28 November 2019

Planning application A/110/19/HH – Field House, The Thatchway

Date: APRIL 2019 18/4553/7

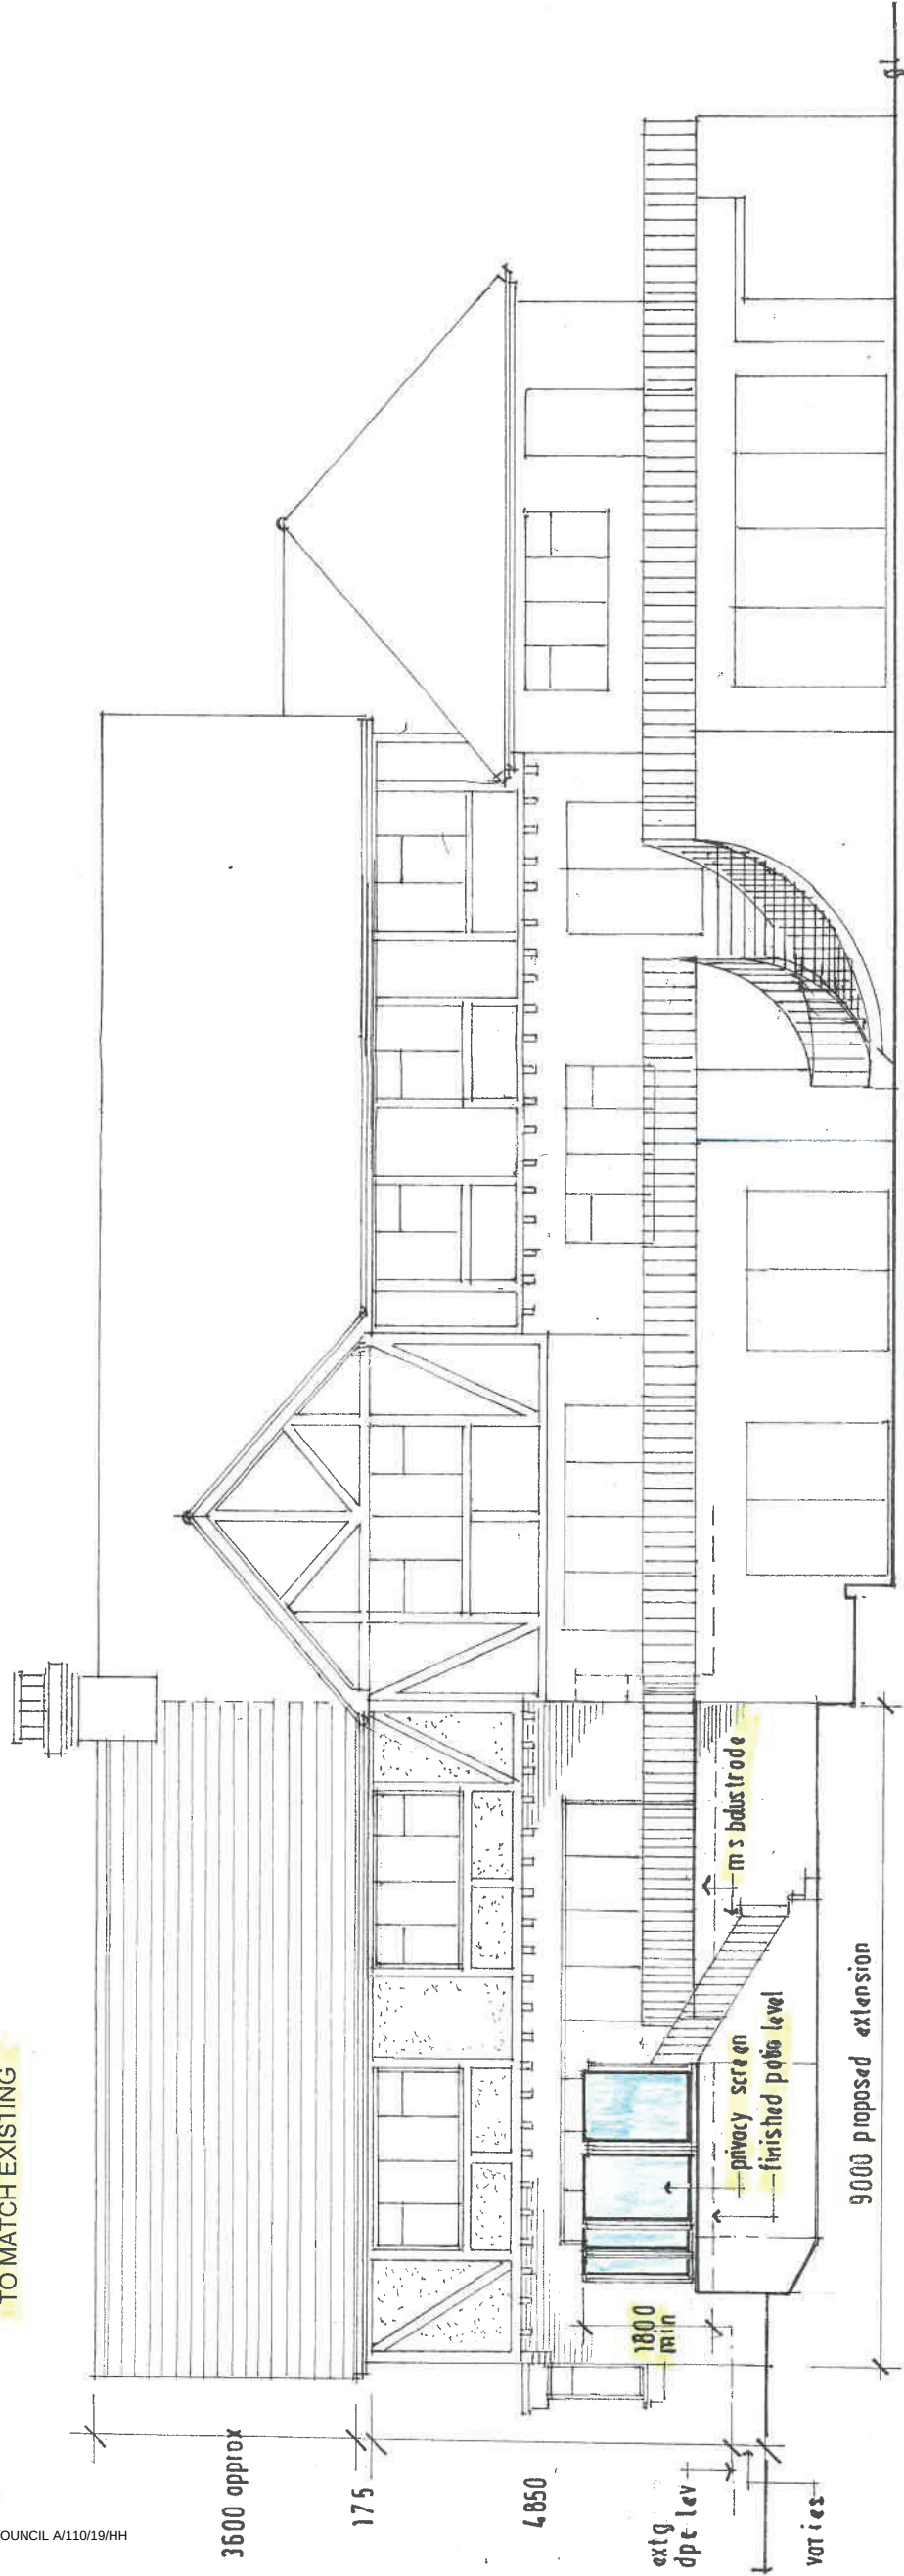
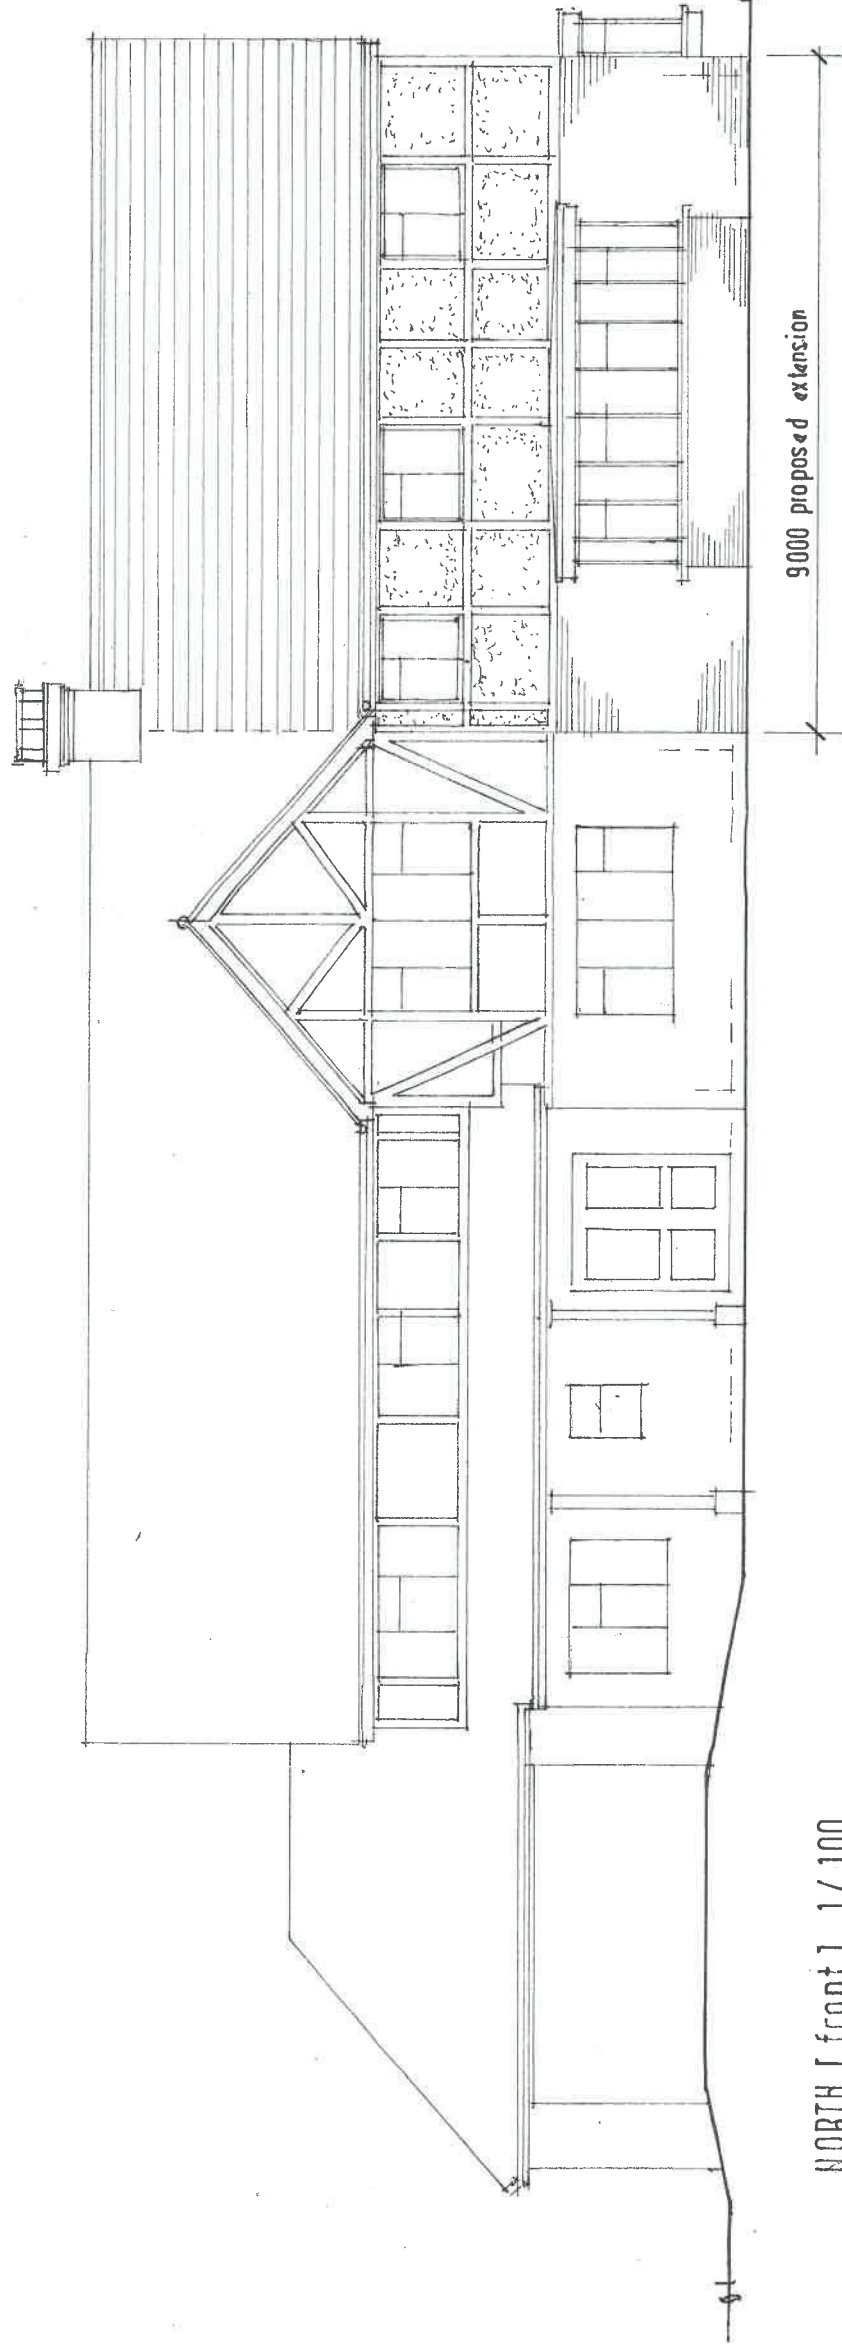
Unfortunately we do not find the proposed revisions to the plans at all satisfactory. The fact that it is now proposed that the west wall will no longer be a brick wall but a completely “frosted” glass wall is particularly unsatisfactory, as that is what we will see every time we drive into our driveway, with the whole 1.8m high by 3 m wide screen visible above our fence, and only one metre from it.

On the other hand, the proposal to extend this screen of frosted glass across the back of the patio in front of the western patio windows on the extension is more welcome. Unfortunately, we do not believe that most people would want to live in a house with a privacy screen outside one set of their patio doors. Therefore we are worried that were planning approval be given to the revised design the first thing that will happen with new owners is that the privacy screening would be removed and that we will be left totally overlooked as per the original planning application.

PRIVACY SCREEN DETAIL 1/50

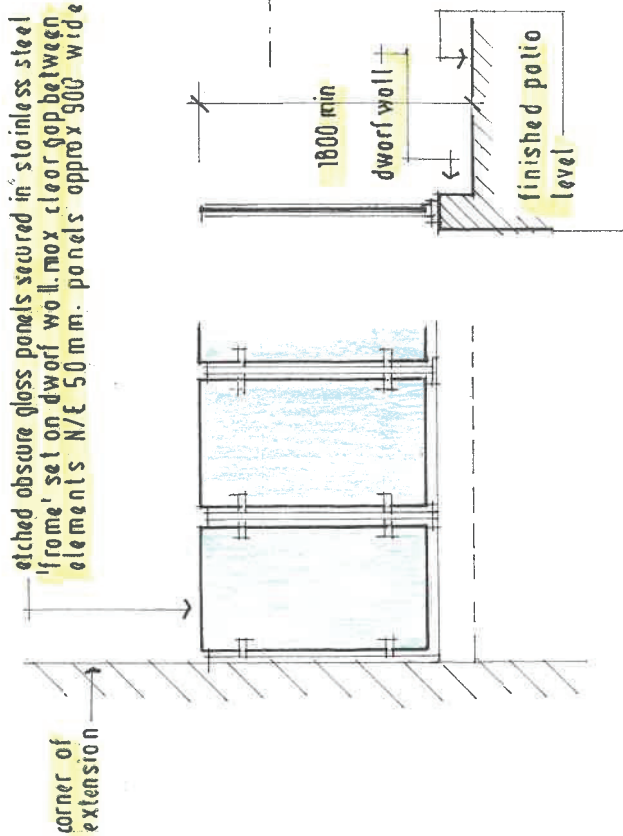
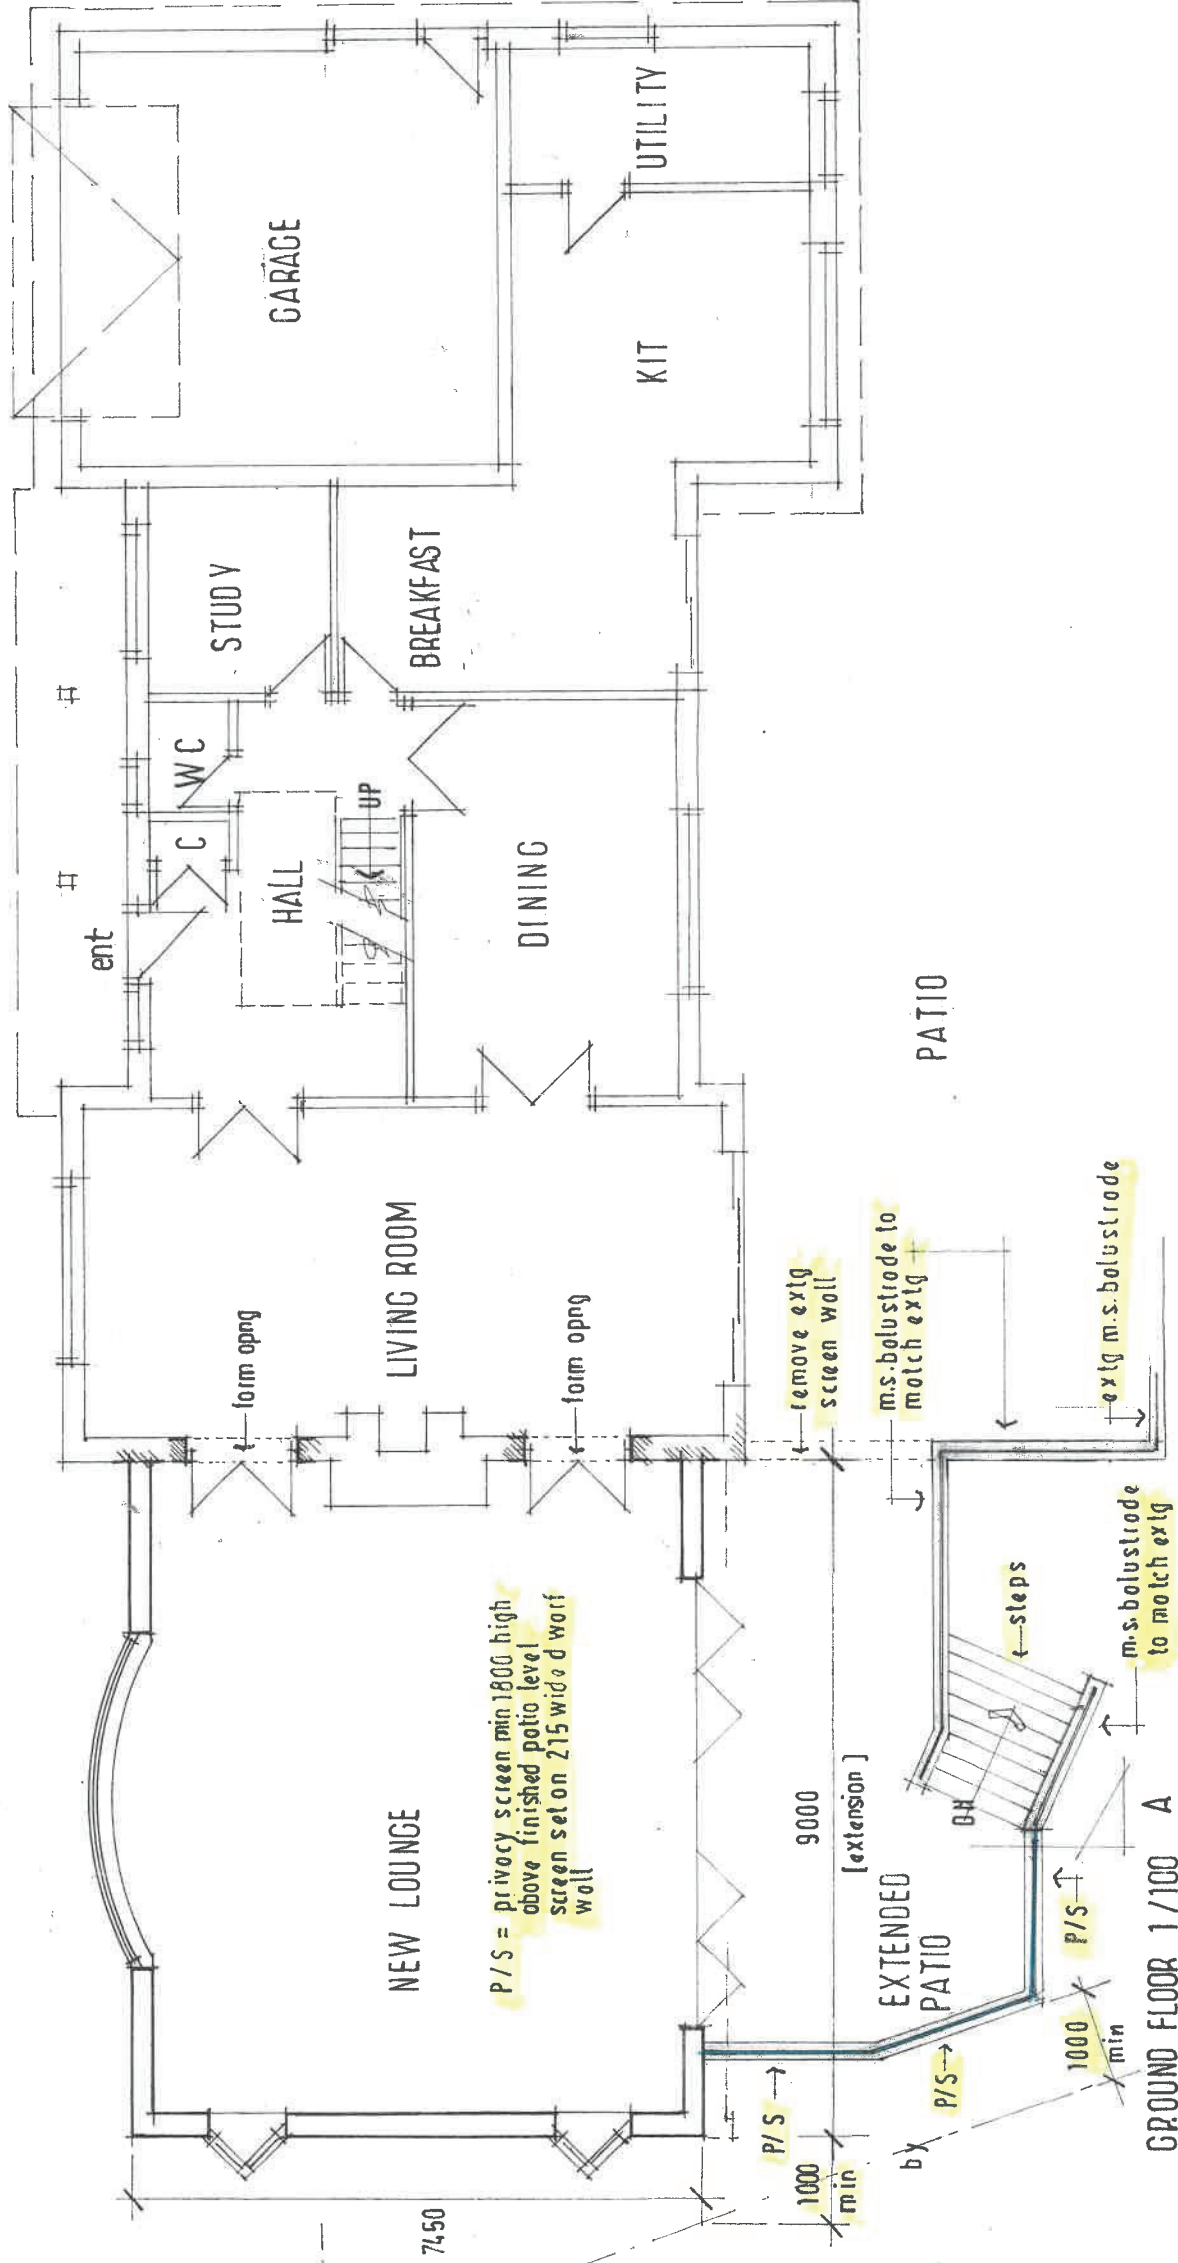
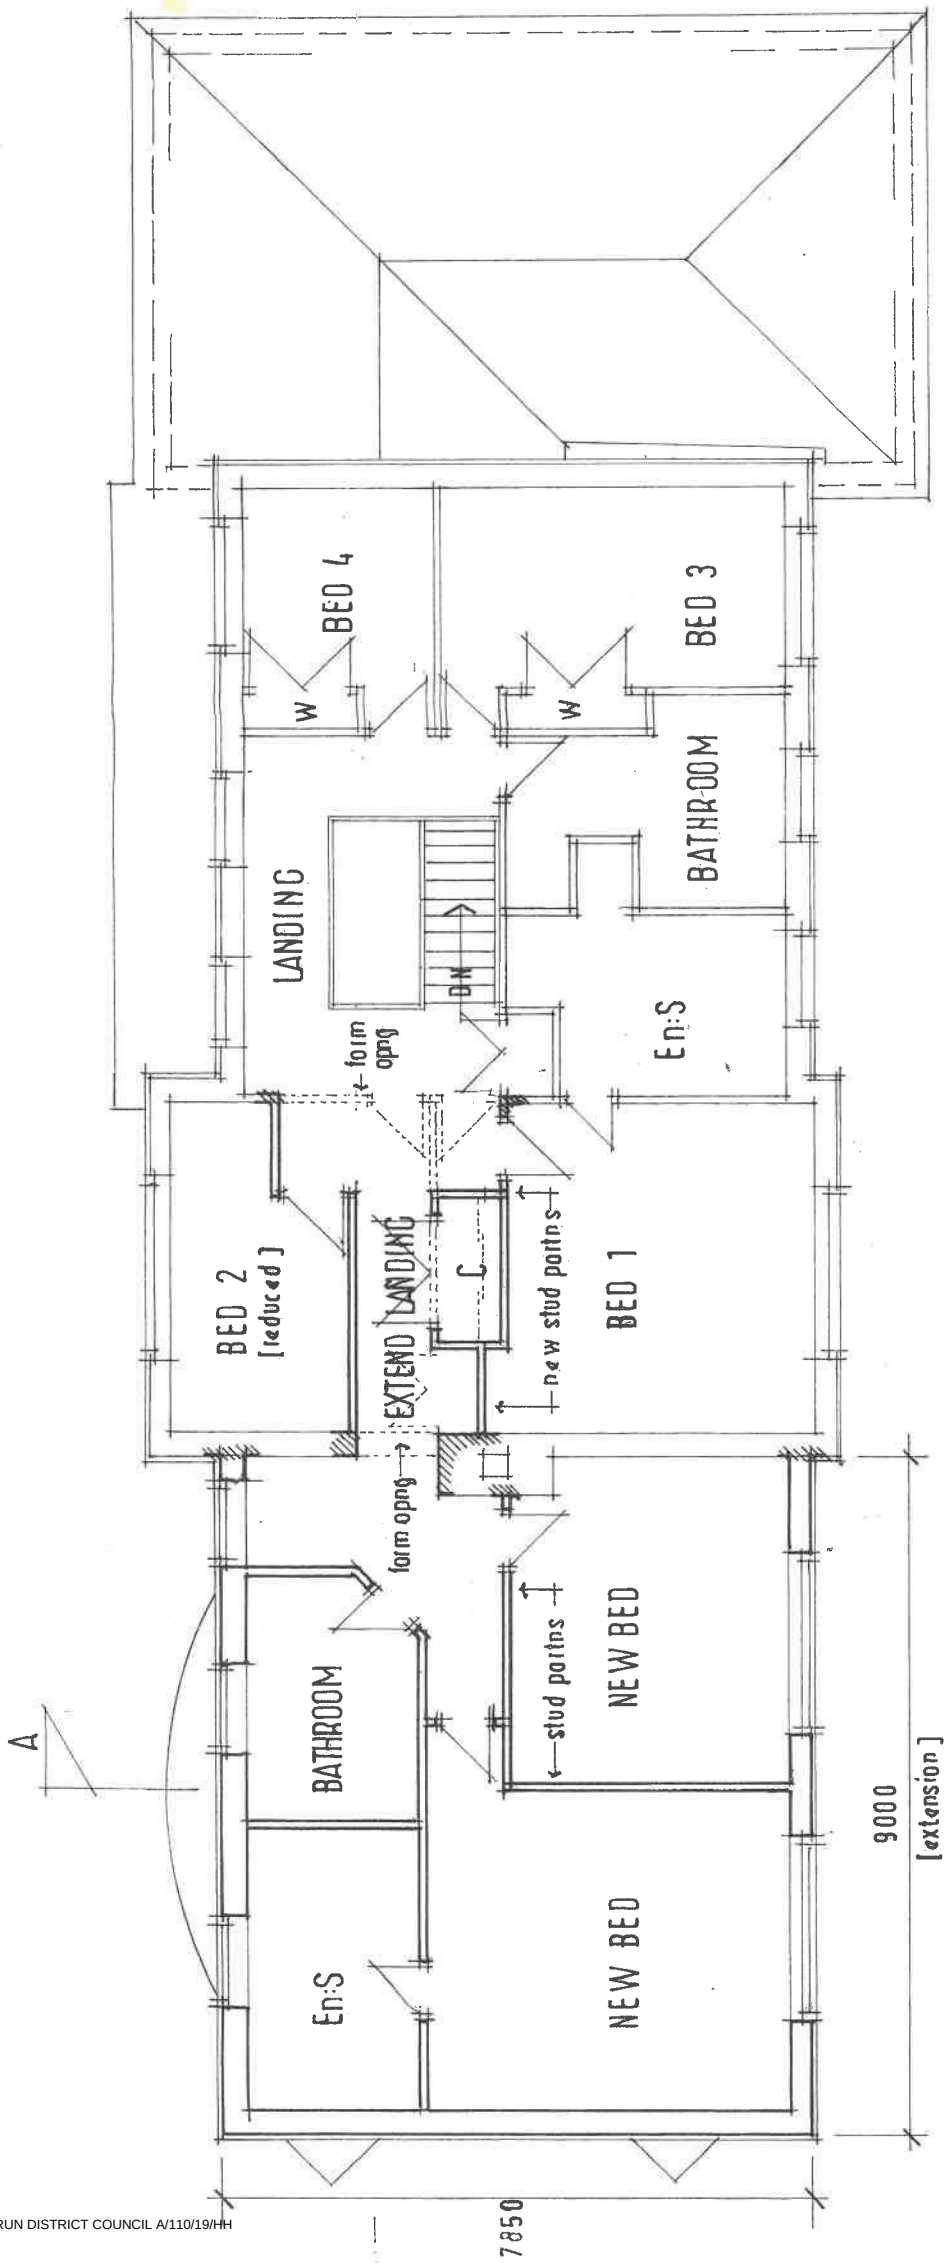
As we said before, we would ask that the design be revised so that there is no extension to the patio at all, **or at the very least so that the patio extension is curtailed so that it does not come west of the eastern set of patio doors.** This would resolve most of our concerns.

- The brick wall at the western end of the patio be reinstated, but to be at a uniform height of 1.8m to the southern edge of the patio, rather than to the design originally submitted (which was 1.8m high next to the house falling away to about 1m at the outer – southern - side, and which would have allowed the owners to look directly across our front driveway to the west).
- The southern side of the patio to have the proposed privacy screen, subject to the following conditions being attached to any planning approval of this:
  - a) the privacy screen to be uncoloured, frosted glass.

- b) it be a condition of planning approval that a privacy screen be built on the south face of the patio extension as per the approved design and that this screen stay there and be maintained in perpetuity, or until such time as a planning application is approved to change this.
